Application No: LU/302/21/HH
Site Address: 2 Purbeck Place Littlehampton BN17 5DP
Description of works: Installation of 3 x roof lights to side and rear and installation of suntiles on existing outbuildings (This application may affect the character and appearance of the Littlehampton (River Road) Conservation Area)

OWPC41320

2 Purbeck Place
Roof Plan
Scale 1 : 100

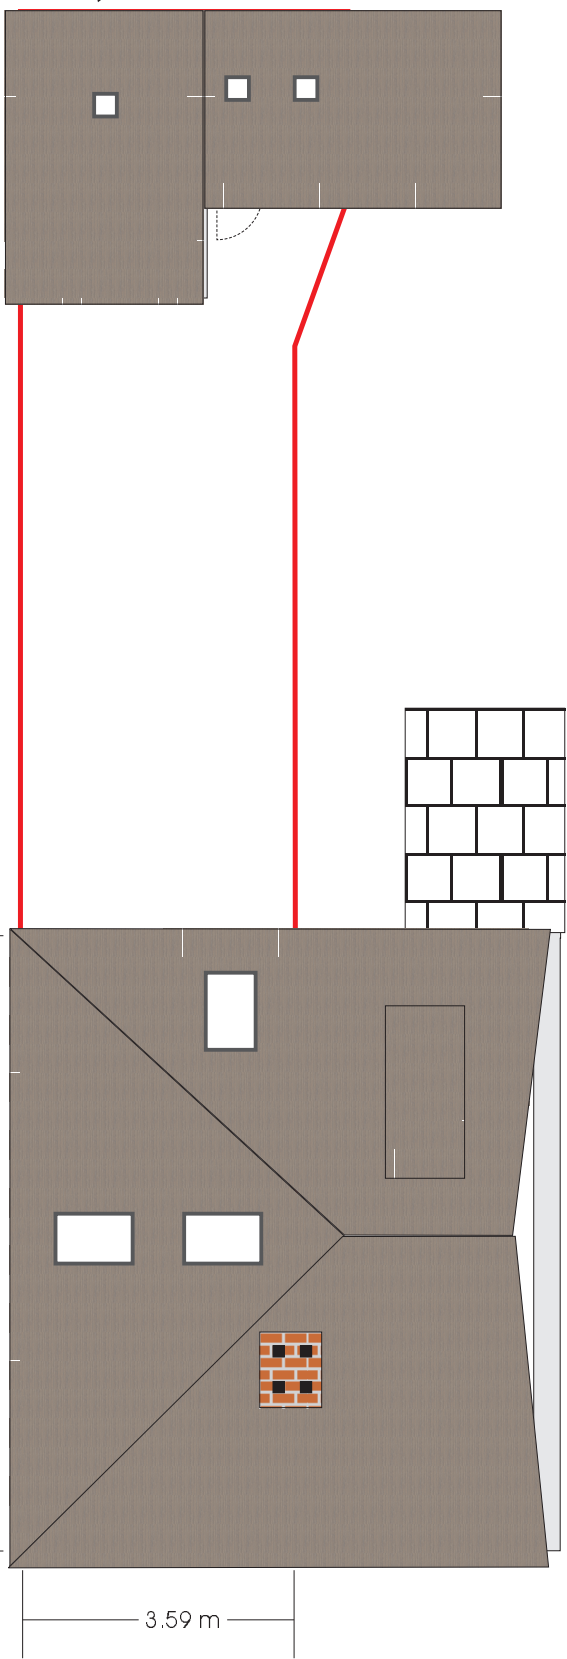
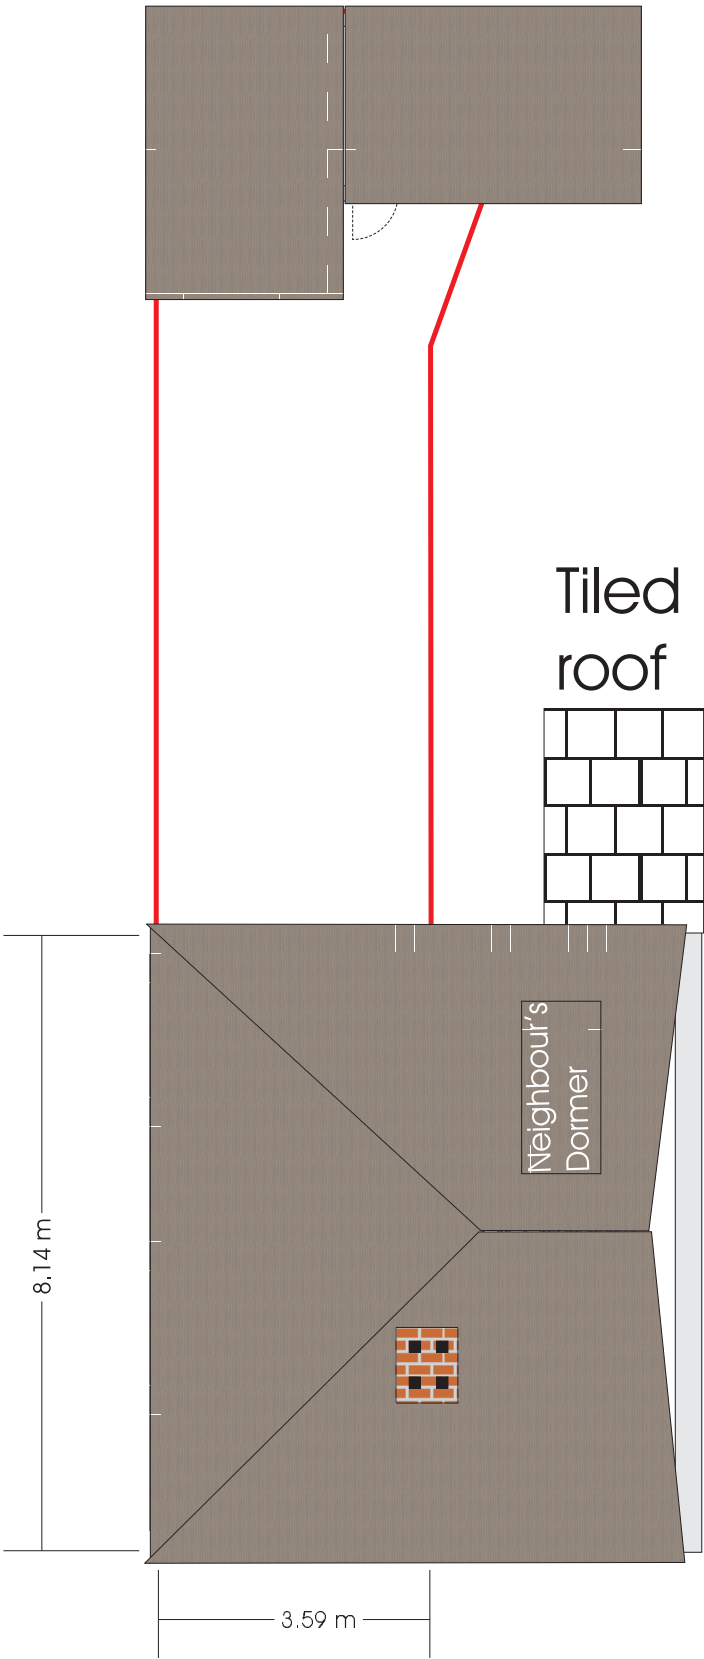
The proposed works to no2 are minor in nature involving small alterations to the outbuilding and in relation to the main building the installation of two roof lights in the southern roof slope and one to the western slope.

Given the heritage significance of the building and its location within a conservation area it is strongly recommended that the roof lights should be of conservation style to ensure an appropriate design with the minimum necessary projection from the roof slope.
